Claire Booth
Planning
Ribble Valley Borough Council

Ecological comments

Planning Application No: **3/2012/0780**
Proposals: **Proposed erection of a detached garage and carport**
Location: **Lower Monubent Farm**
District: **Ribble Valley**

**PROPOSED SITE PLAN**

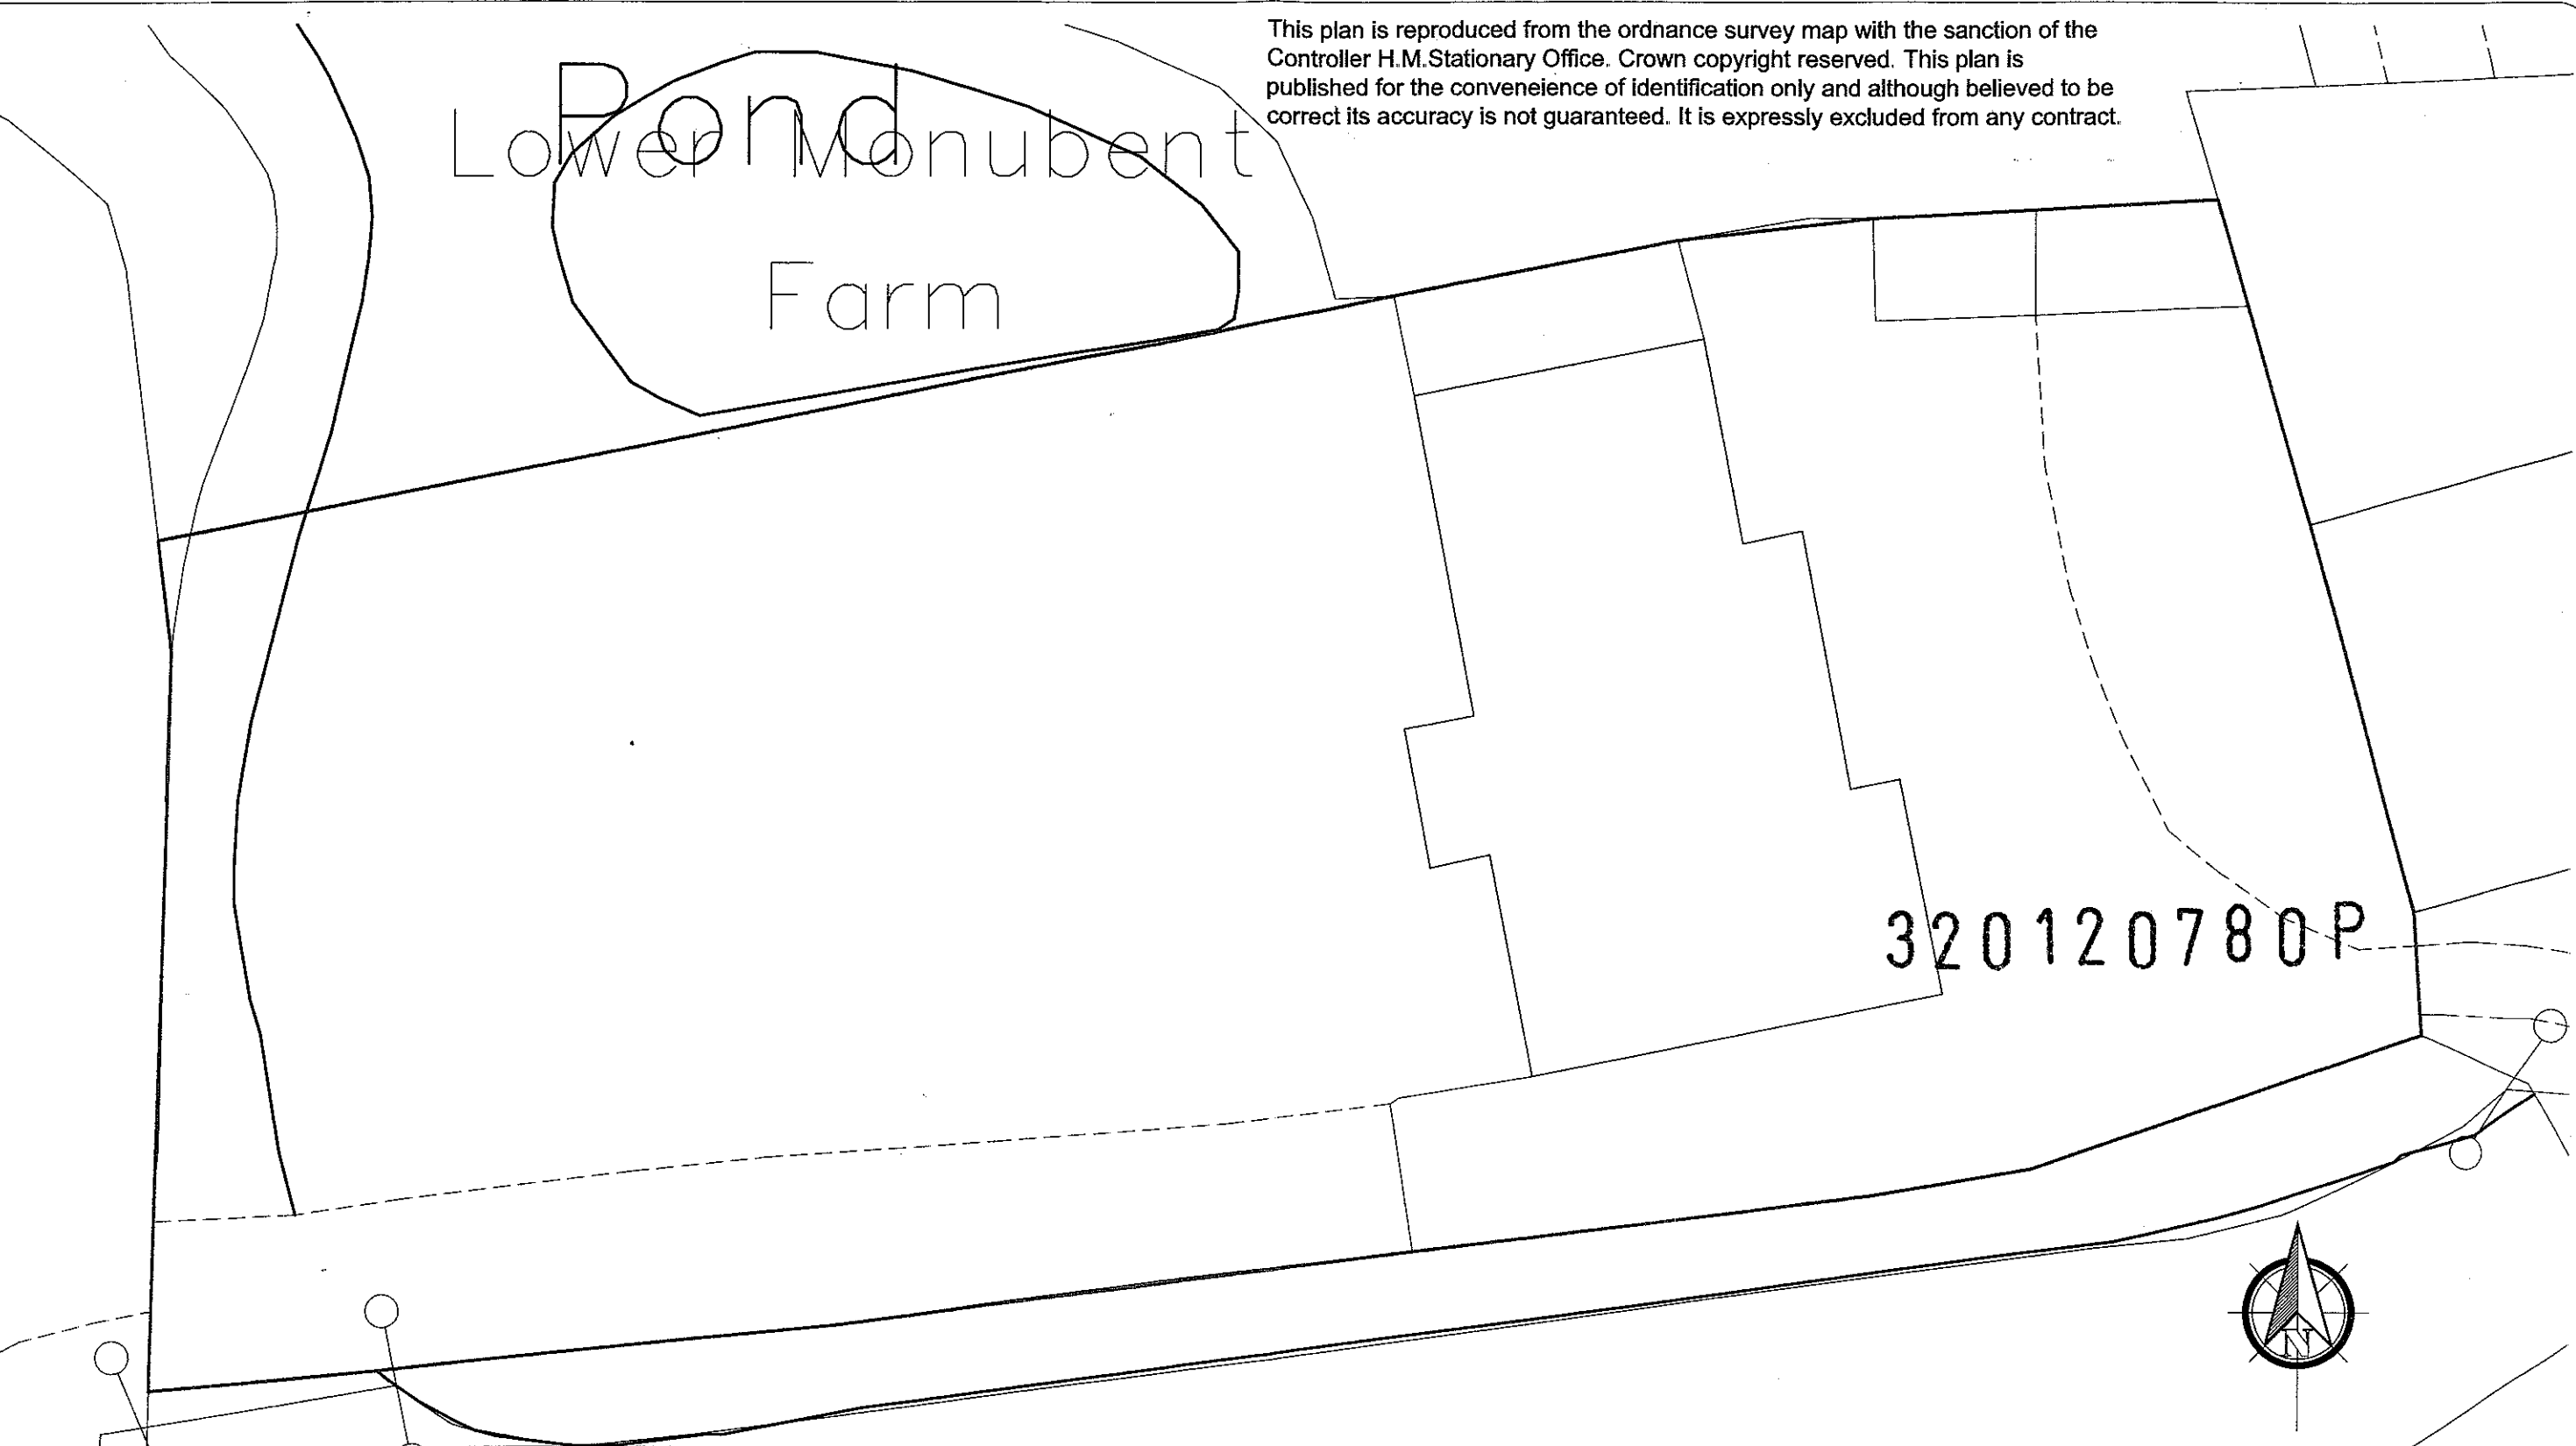
The location of the proposed garage and carport is restricted to the forecourt area and partly on the footprint of the former buildings. Although our records show that the footprint of the proposed development is partly within Lower Monubent Meadows Biological Heritage Site / BHS 75SE10, reference to historic aerial photographs and mapping indicates that this is due to an error in the mapping of the BHS boundary. I therefore conclude that the development would not result in a loss of BHS extent. Provided that no materials are stored on the BHS, it seems reasonably unlikely that the proposals would result in any impacts on the BHS.

Aerial photographs and records accessible to Lancashire County Council indicate that there is a pond in close proximity to the proposed development. This pond may have the potential to support Great Crested Newt, as well as other amphibians including Common Toad (a Species of Principal Importance). As the proposed development is restricted to the forecourt area and due to the scale of the development it would be unreasonable to require surveys. However, as Great Crested Newt and other amphibians may be in the area it would be appropriate for materials to be stored on hard standing, in order to avoid amphibians using them as a temporary place of shelter, and for any possible places of shelter to be affected by the development (such as rubble piles etc) to be searched carefully prior to removal. This and the above matter regarding the BHS can be dealt with by the following **planning condition**:

It is not clear from the information submitted and aerials photographs whether or not any potential habitat for breeding birds will be affected by the proposed development (for example piles rubble, scrub etc). If potential breeding habitat for birds is to be affected then I recommend that the following **planning condition** is attached to any approval in order to avoid impacts on nesting birds during the works:

- In order to avoid potential impacts on amphibians and Lower Monubent Meadows Biological Heritage Site:
 - The storage of materials and vehicle movements associated with the proposed development shall be confined to the forecourt area / hard standing.
 - All areas of suitable terrestrial habitat for amphibians, including likely places of shelter (such as rubble piles), shall be carefully searched immediately prior to

- removal / development works. Any amphibians encountered shall be moved to a safe area of suitable habitat, which will then remain undisturbed.
- If the presence of Great Crested Newt is detected or suspected at any stage before or during development works, then works must not proceed until advice has been sought regarding the need for Natural England a licence.

- Vegetation clearance works, clearance of any other potential bird nesting habitat or other works that may affect nesting birds will be avoided between March and August inclusive, unless the absence of nesting birds has been confirmed by further surveys or inspections.
